TOWN AND COUNTRY PLANNING ACT 1990

FULL

Reference: H18-0979-24 **Date of Decision:** 29th May 2025
Applicant: Mrs M Stone
8-9 Grange Farm
Hospital Road
Sutton Bridge
Spalding
PE12 9YR
Location: Adj 8-9 Grange Farm Hospital Road Sutton Bridge Spalding
Description: Proposed conversion, extension and change of use of barn to kennels

PLAN AS PROPOSED

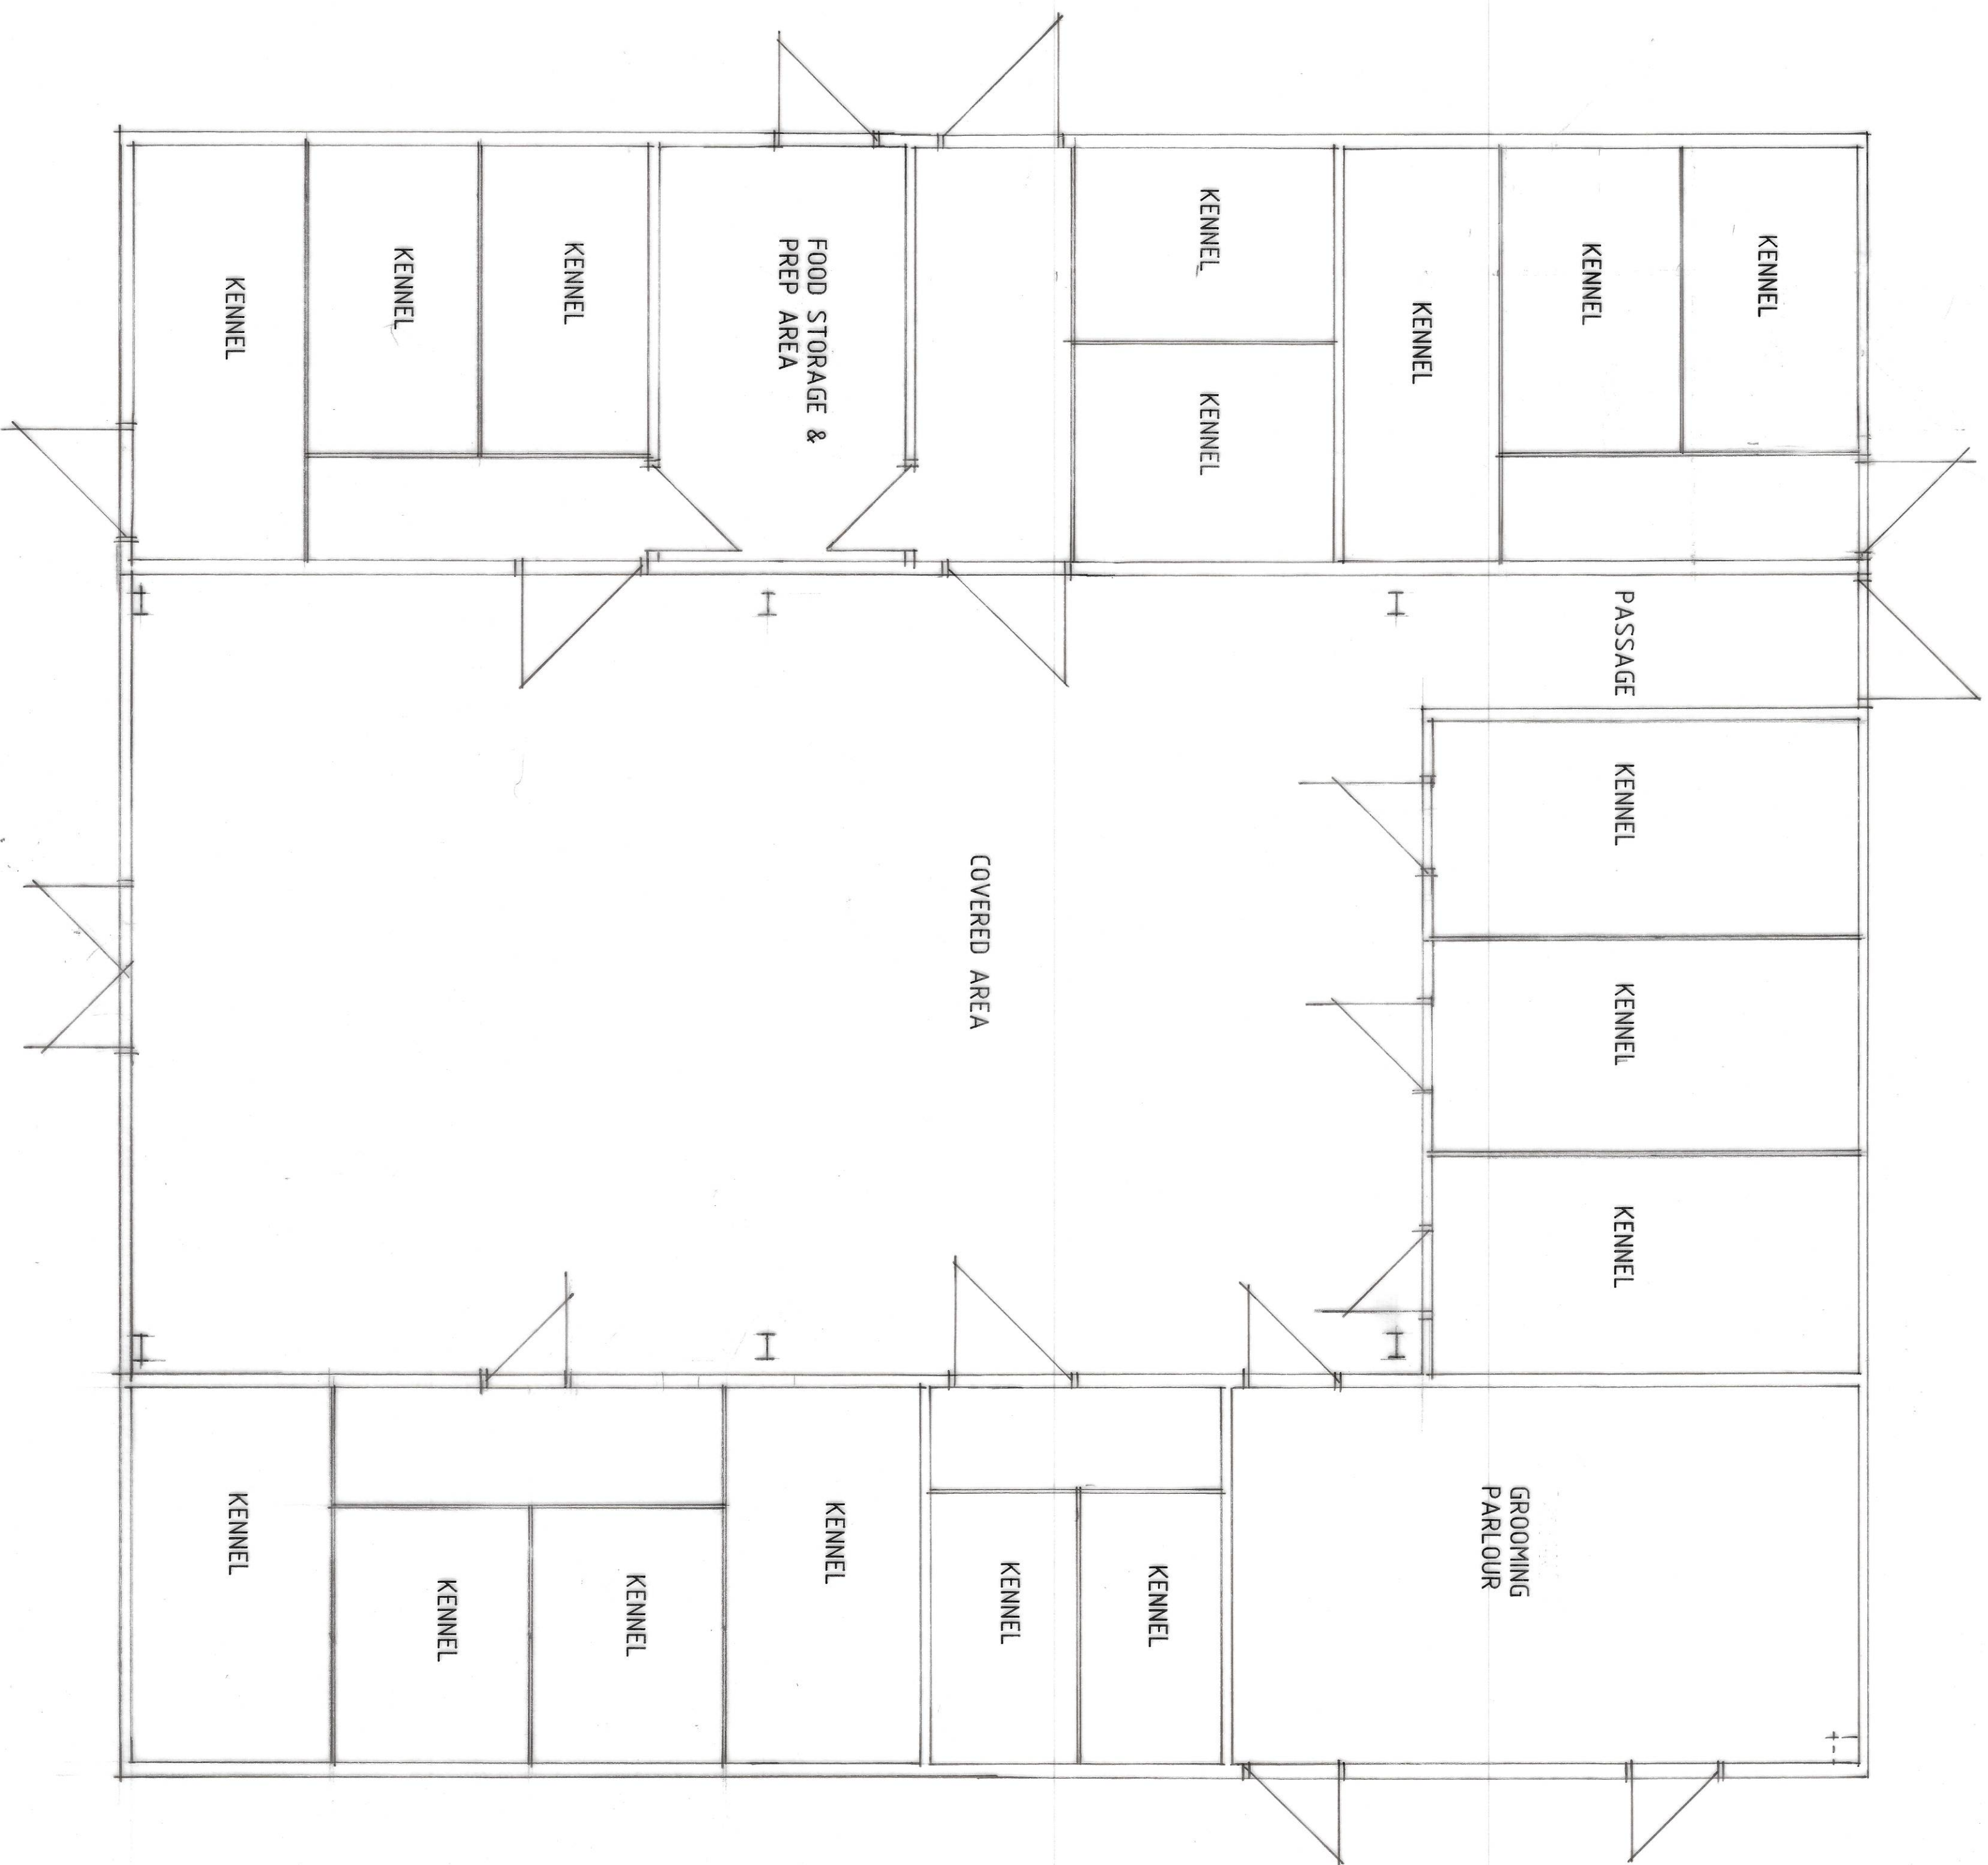
The extension in terms of design, scale and its overall nature would result in a harmful impact to the character of the area. Due to the existing use of the barn, the current layout, design and appearance, which in part is formed through the 'u-shape' layout and style, is in keeping with the rural agricultural context of the area that it is located within.

The extension would remove this design feature, altering the natural form, layout and context; this coupled with the proposed change of use, would substantially erode this sense of agricultural character, changing the overall context, feel and design. Furthermore, the poor quality design fails to enhance or improve the area/existing barn and if approved, would appear harmful and out of character.

As a result of this, by virtue of its design, scale and nature, the extension would appear out of character and incongruous. Likewise, the resultant use would adversely impact the character of the area, introducing a somewhat commercial business that would create further harm to the impact of the character.
